# BUILDING PERMIT

Job ID: 2012-09-4873-CH OF USE

has permission to COU, 1st fl left to Sandwich shop, dwellings above  
provided that the person or persons, firm or corporation accepting this permit shall comply with all of the provisions of the Statutes of Maine and of the Ordinances of the City of Portland regulating the construction, maintenance and use of the buildings and structures, and of the application on file in the department.

## Conditions of Approval:

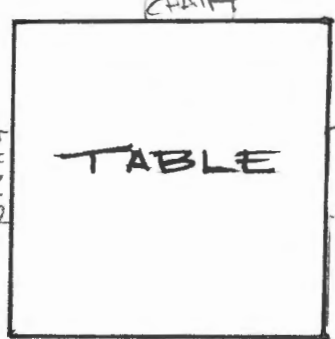
7. The proposed range/oven requires a separate permit for a commercial hood exhaust/suppression system per NFPA 96. As discussed, if an alternate appliance is installed the specifications shall be submitted to determine if a hood is required.

1. The building shall comply with City Code Chapter 10 upon inspection.
2. The floor plans do not indicate adjacent spaces, separations, or egress arrangement. This building is a multiple occupancy building with 3 dwelling units above the nonresidential occupancy. Per NFPA 101:31.1.2.3 **the dwelling units and exits therefrom must be**

**separated from the nonresidential occupancy(s) by 1-hour construction and fire doors or the nonresidential occupancy(s) must be protected throughout by an approved, supervised automatic sprinkler system.**
